HKTA / architects

October 1, 2013

About: 133 York Street; Meeting with Planning Staff, Sept. 23 @ 1:00 PM

1 FIRST FLOOR PLAN
A-101 Scale: 1/4" = 1'-0"

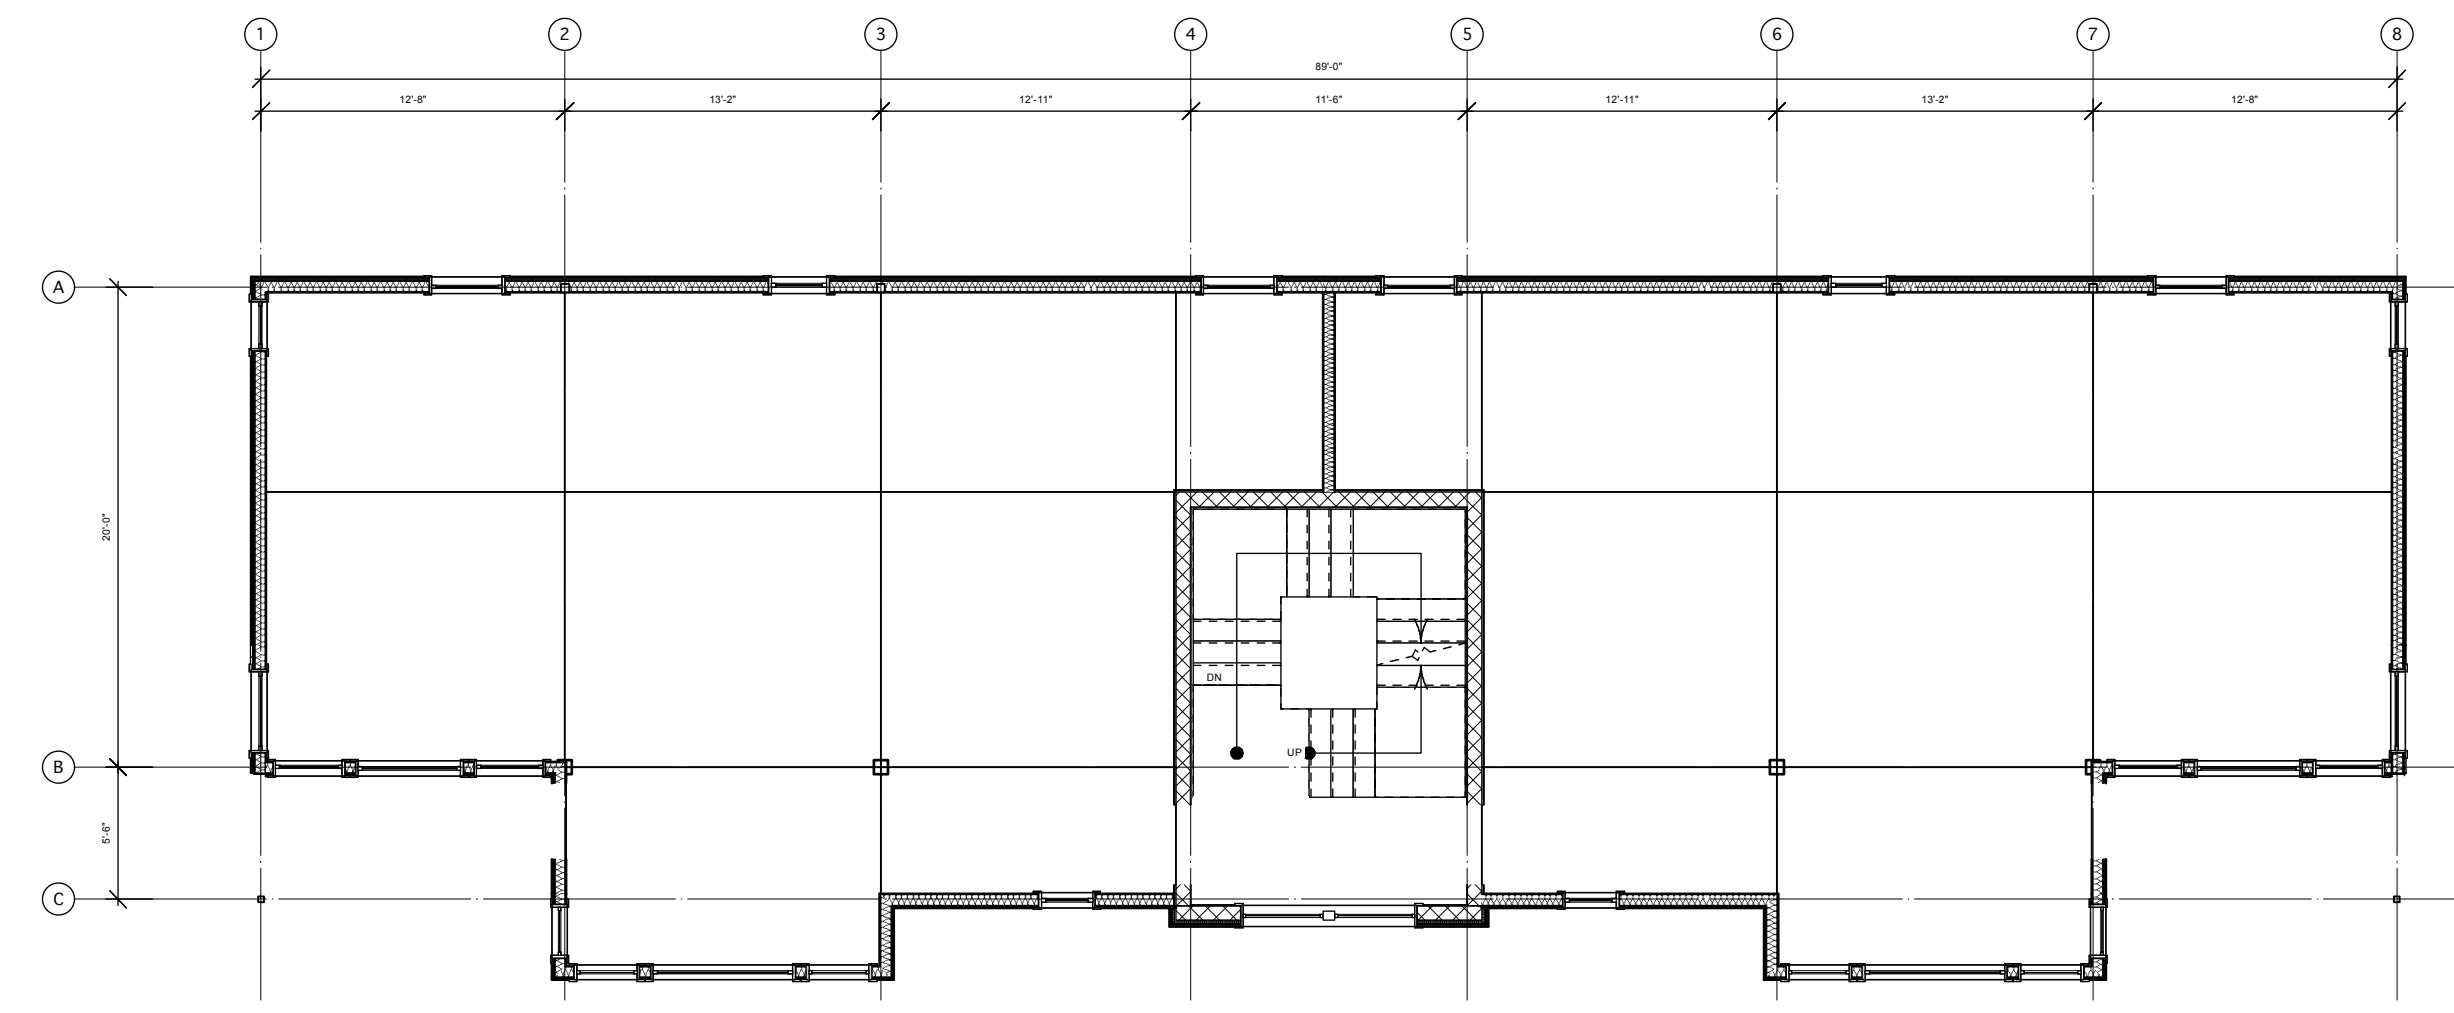
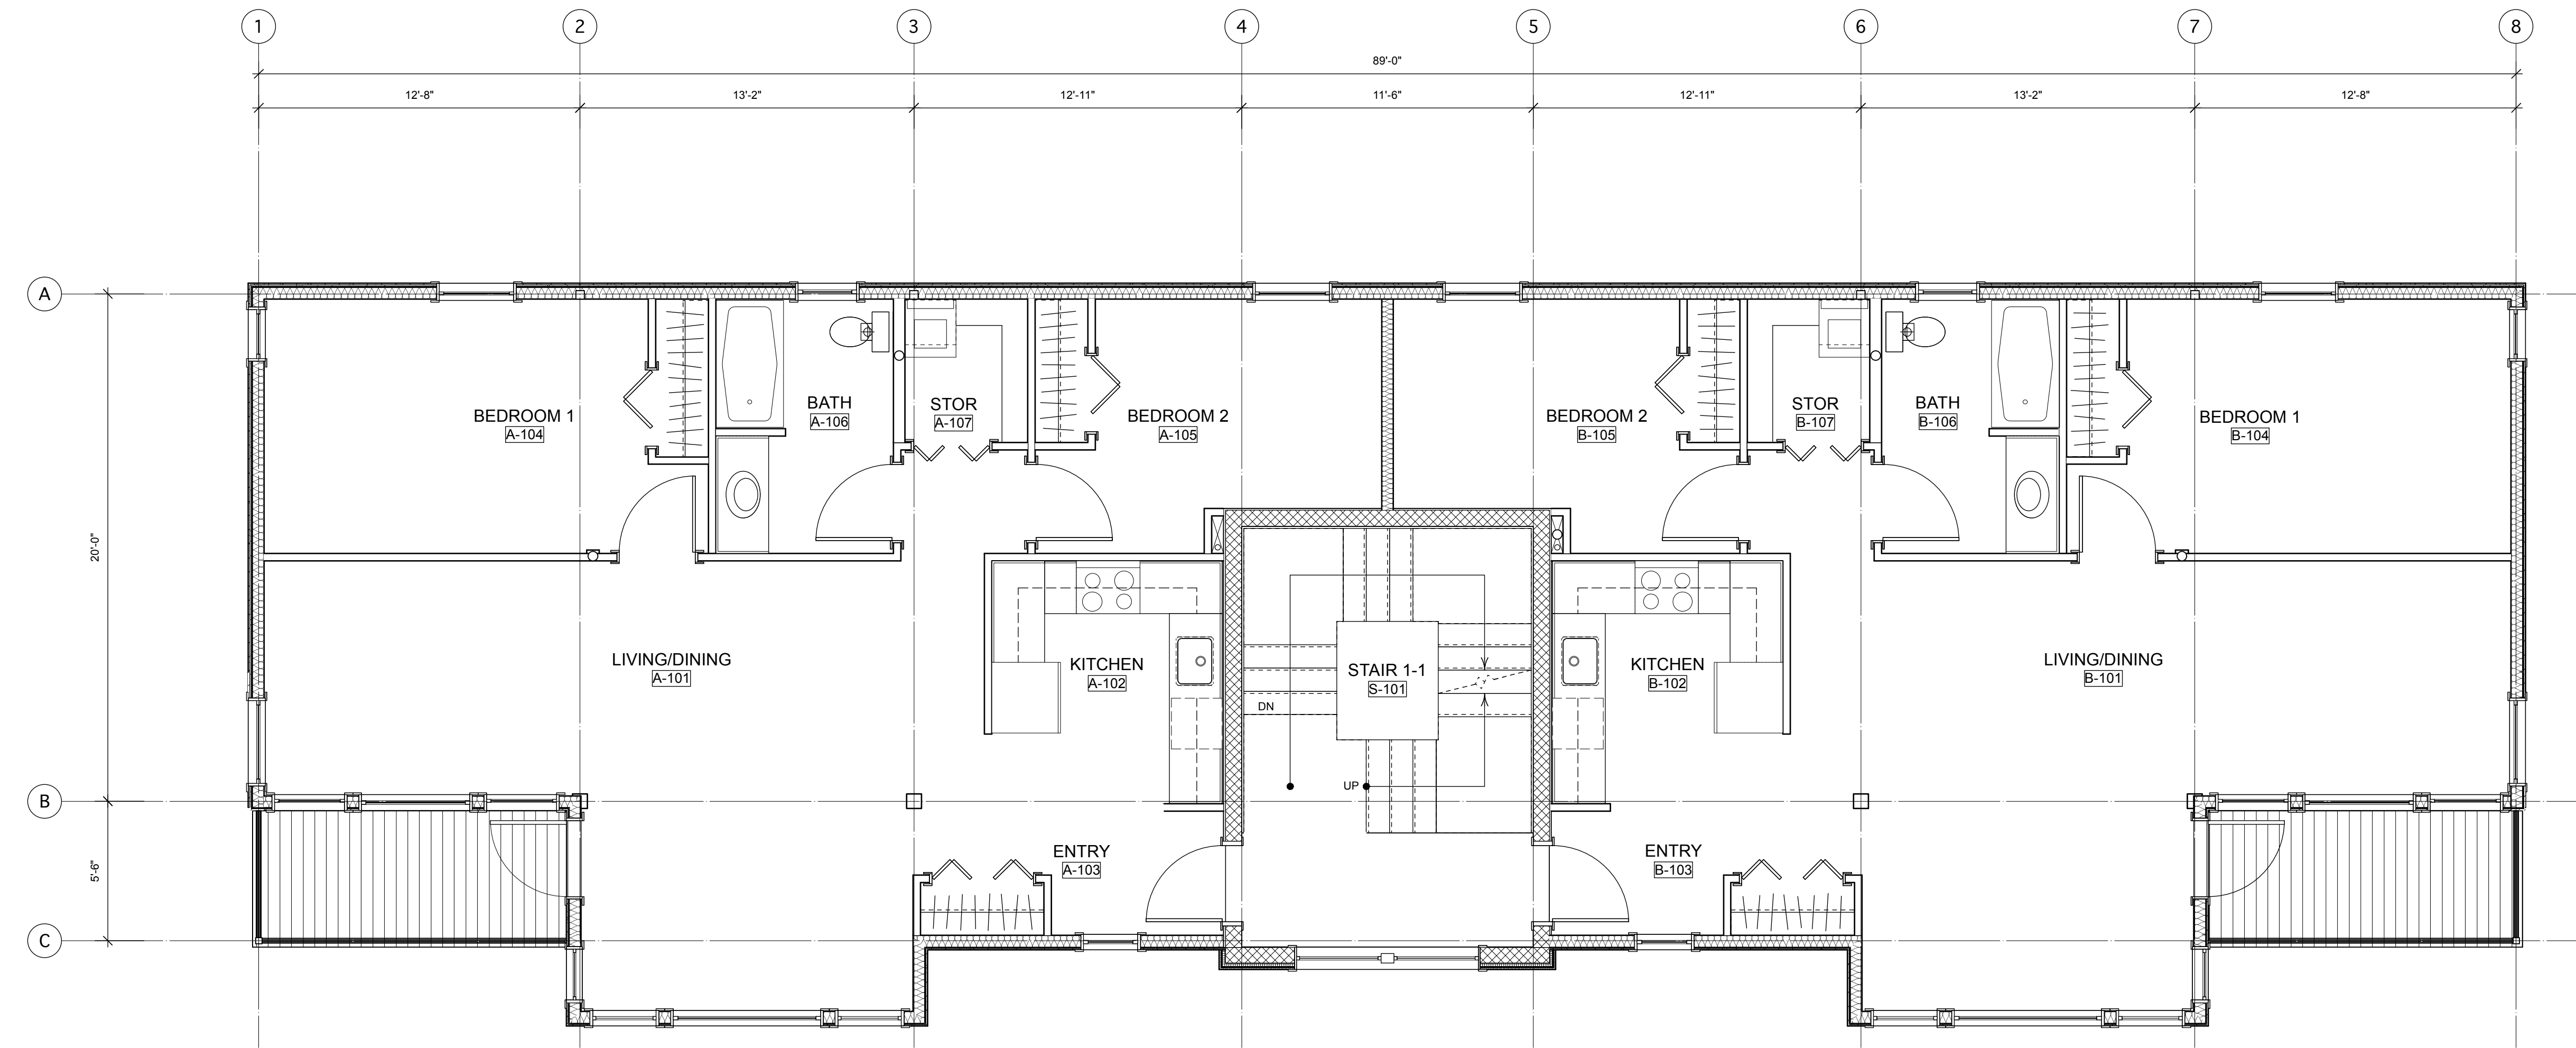
We were encouraged to create a more open entrance. A wider entrance and one with more glass to create an airiness feel to the lobby was seen as desirable and in keeping with Design Principles. While the entrance and stairwell to the owner units are already well light by natural light from windows on each floor, which will flood the stairwell with light, a more generous entrance assembly was considered necessary at the first floor. (Final submittal provides a larger opening on the first floor).

1
A-202
NORTH ELEVATION
SCALE: 1/4"=1'-0"

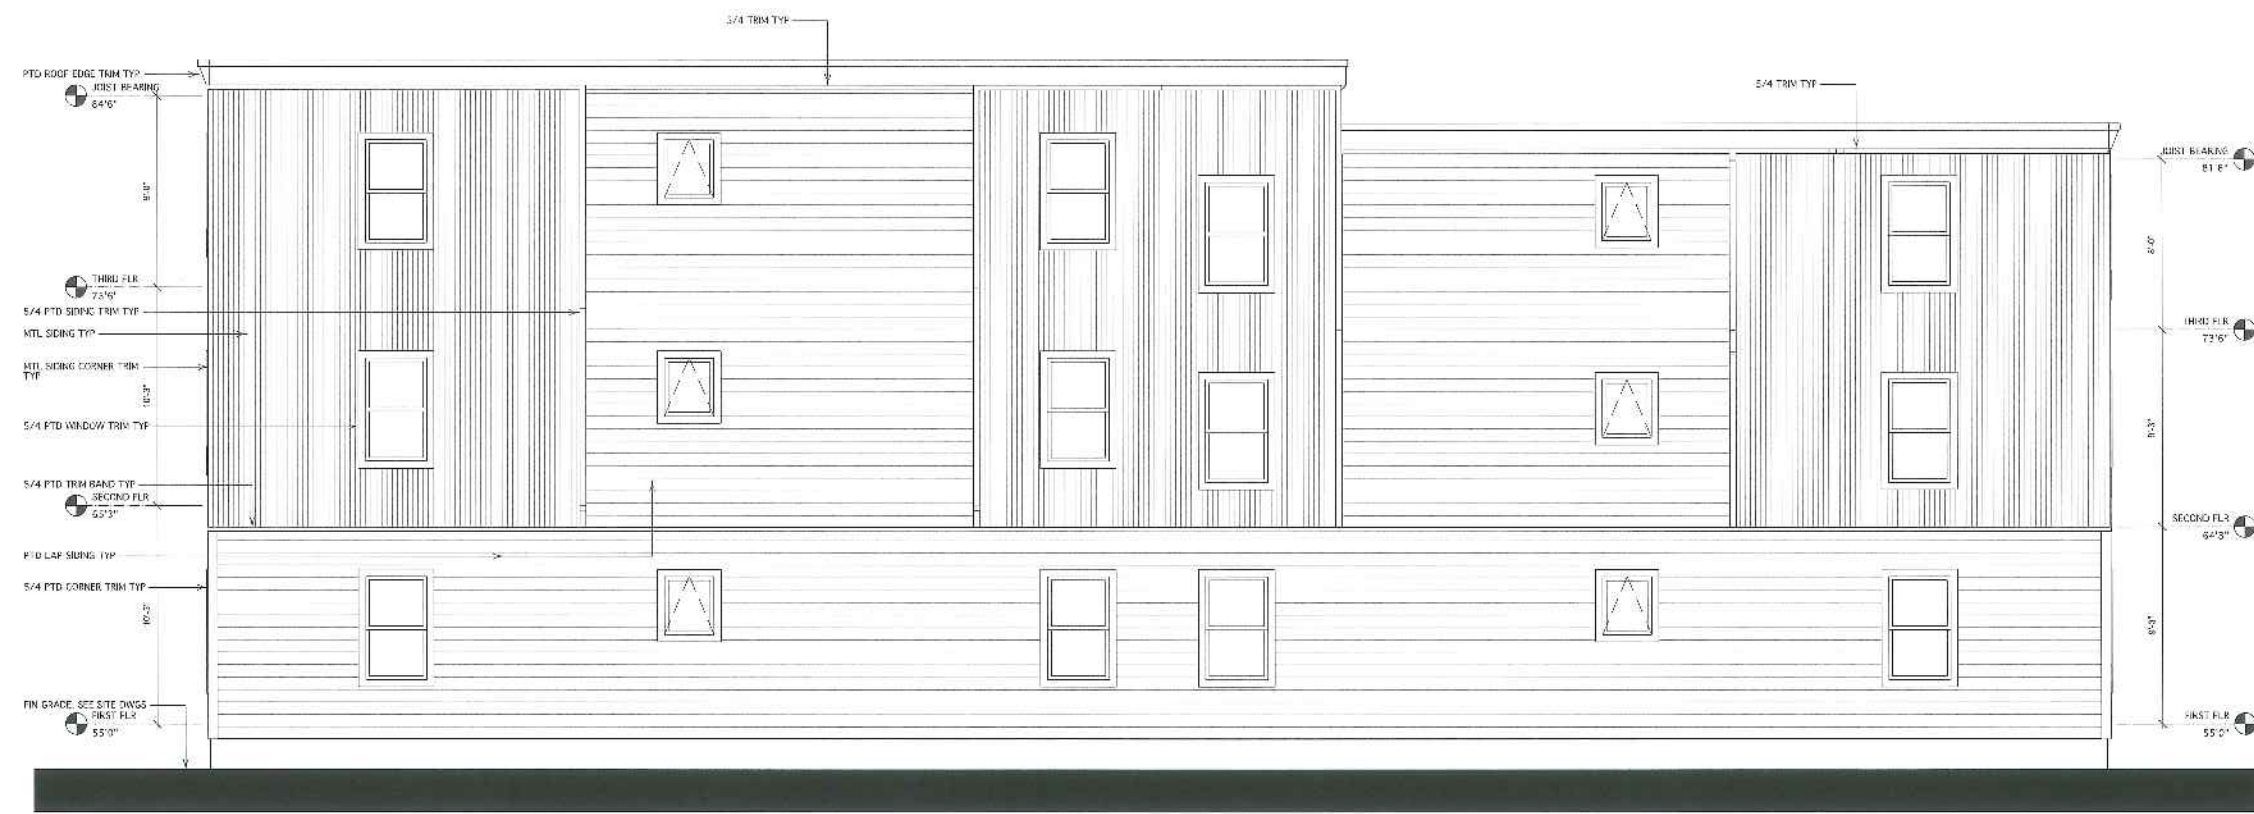
- Design of entrance
- Materials and colors (raised by neighbor and PB members)
- Rear elevation (lack of articulation/interest) (raised by several PB members)

Discussed back-side elevation and were encouraged to create a more neighborly face and to develop more expression of planes on the back. (The final submittal makes the for a subdivision of the façade into four components each reflective of the interior function and then using the trim elements in the paragraph above to articulate these by using the trim to provide texture and composition).
